Traffic Impact Study_V3 redlines.pdf Markup Summary 2-24-2022

**Figure 6**  
**SITE DEVELOPMENT DISTRIBUTION**  
 (%): Overall  
**SITE-GENERATED ASSIGNMENT**  
 AM / PM Peak Hour

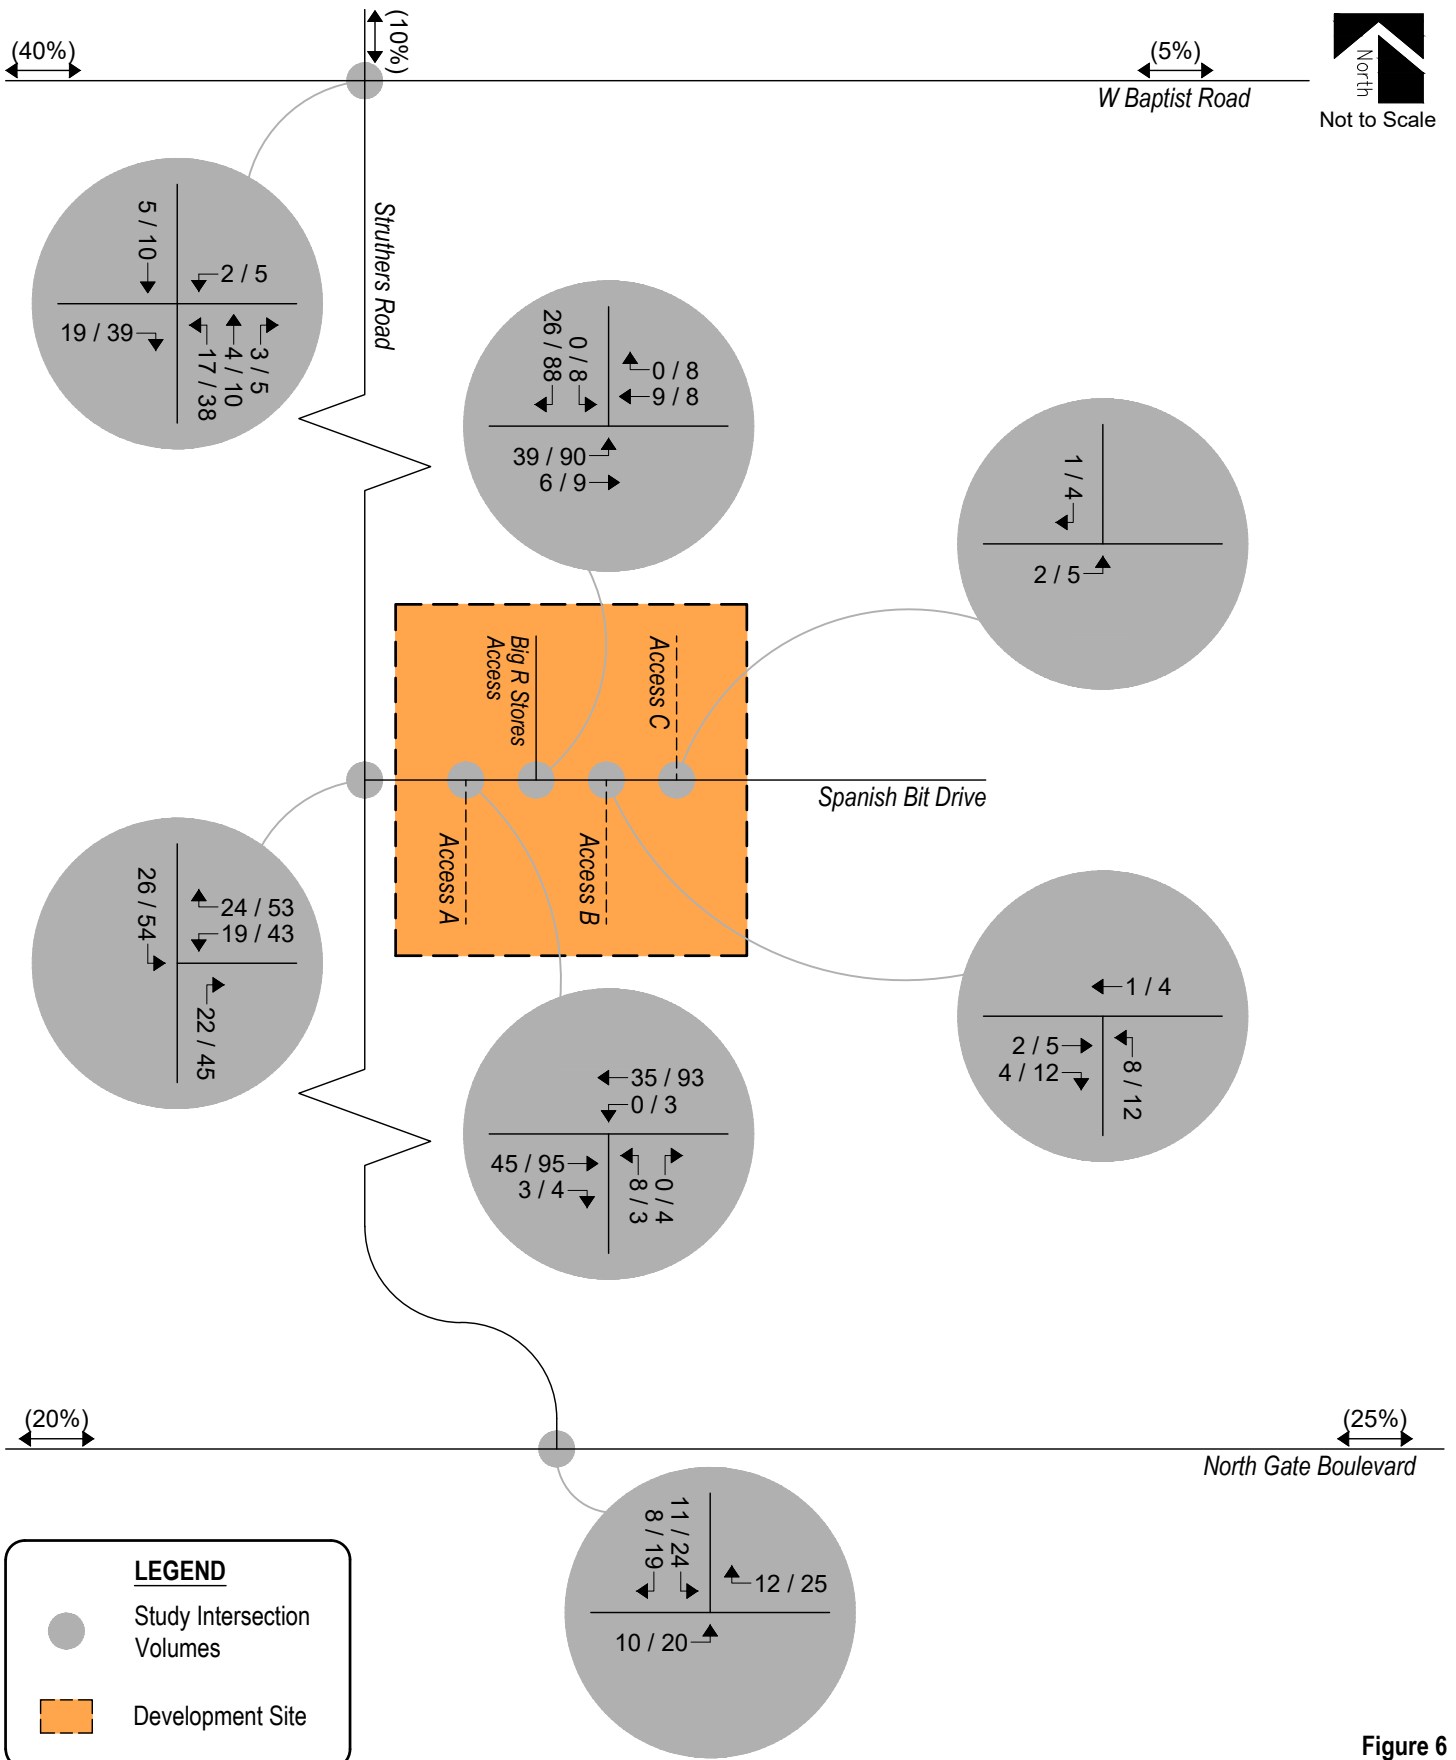
The ECM Administrator does not accept trip distribution. Please contact Lupe Packman at lupepackman@elpasoco.com or 719-313-6215 for further information.
